Re: Sawmill market
1909 Bellamah Ave. NW Albuquerque NM
Traffic Circulation Layout
Engineer's/Architect's Stamp 07-23-18 (J13-D017A)

Based upon the information provided in your submittal received 07-23-18, the above referenced plan cannot be approved for Building Permit until the following comments are addressed:

A1 SITE PLAN
1" = 20'-0"

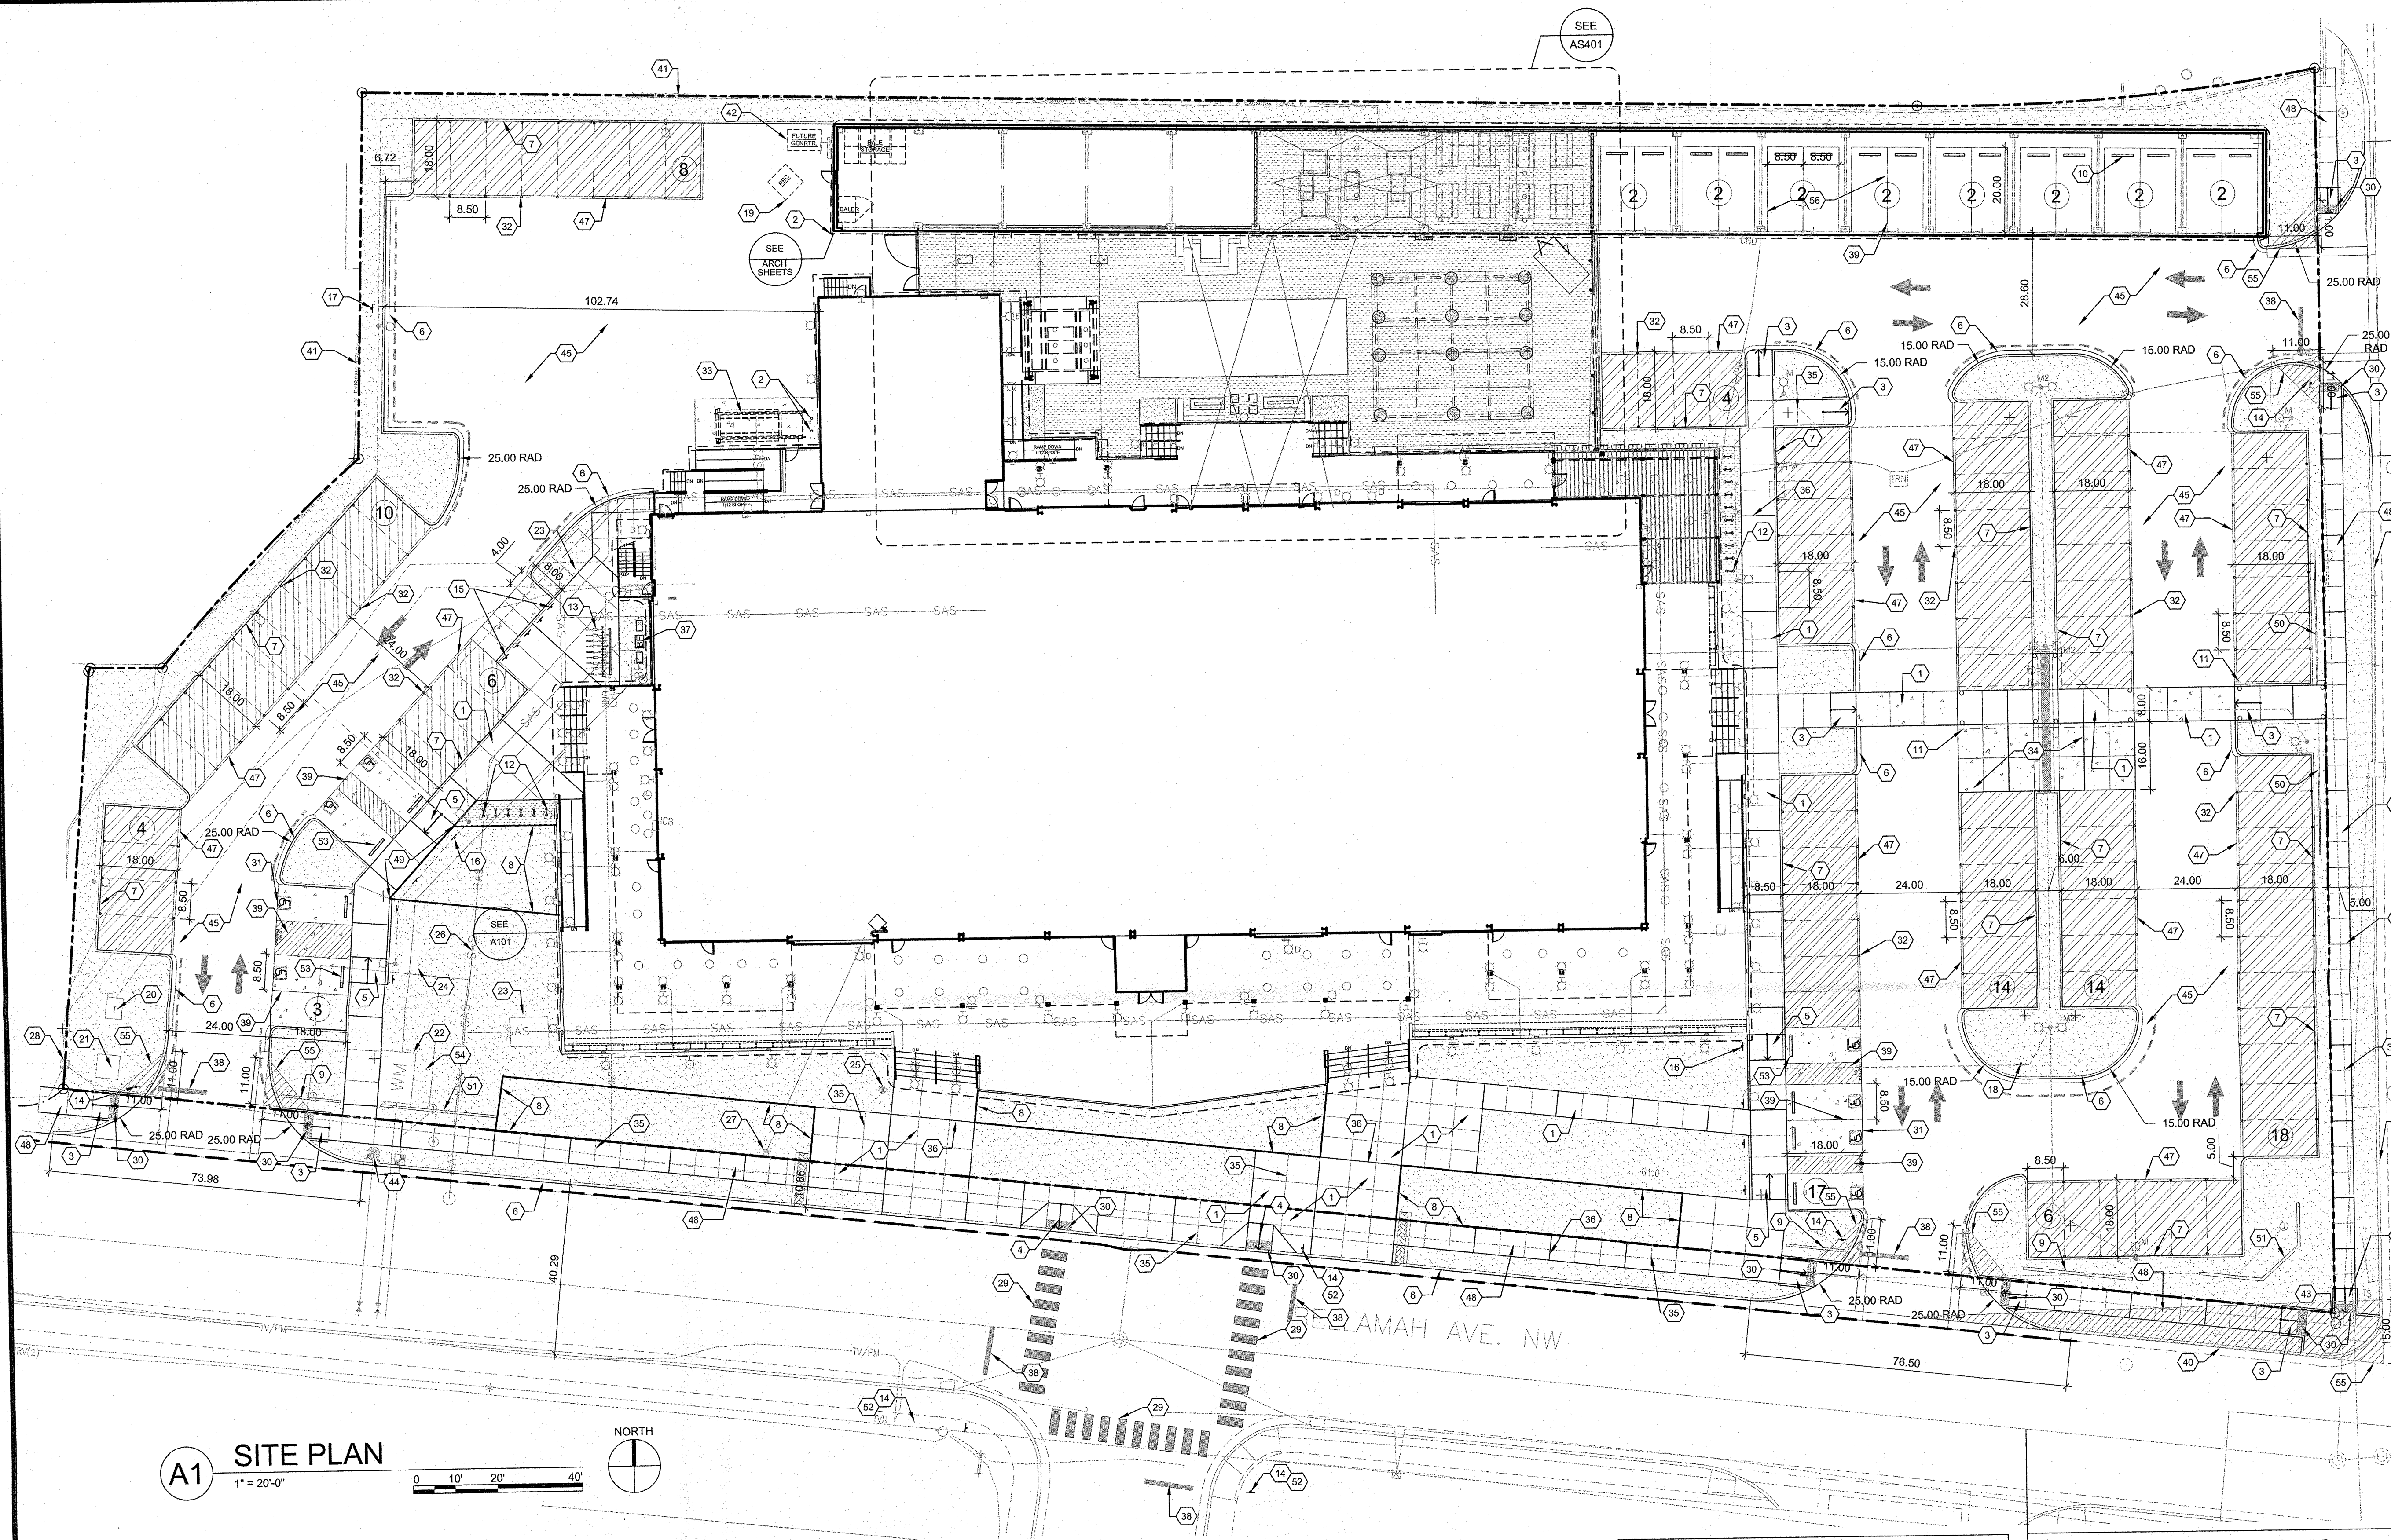
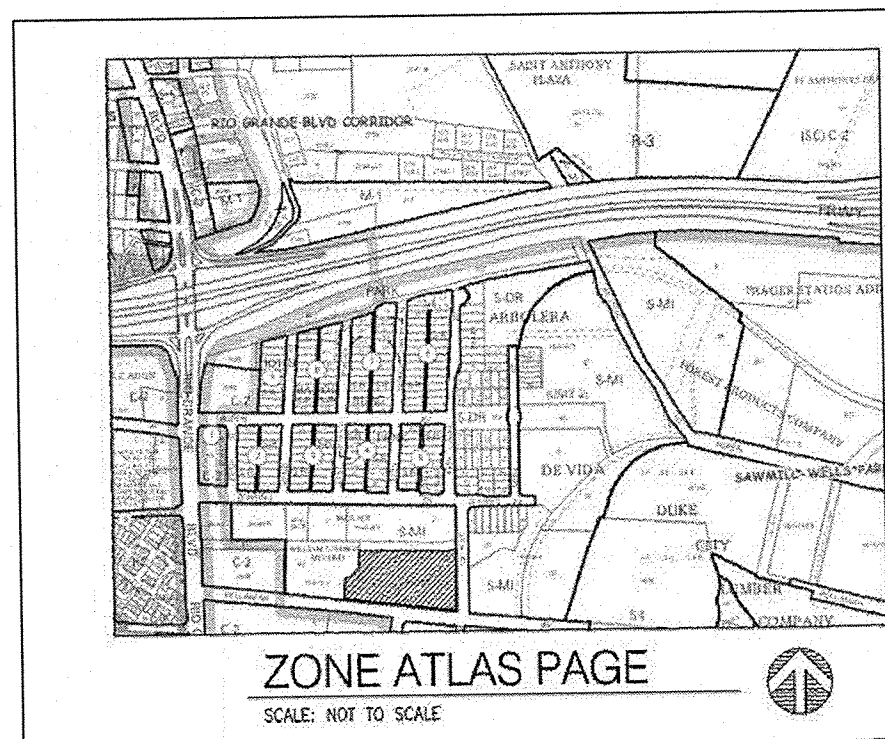
1. Please list the width and length for all existing and proposed parking spaces. Some dimensions are not shown. If the dimension of the parking spaces is mentioned in the key notes, that is also acceptable.
2. Show the clear sight triangle and add the following note to the plan: "Landscaping and signage will not interfere with clear sight requirements. Therefore, signs, walls, trees, and shrubbery between 3 and 8 feet tall (as measured from the gutter pan) will not be acceptable in the clear sight triangle."
3. Take off the bubbles on the TCL sheet.
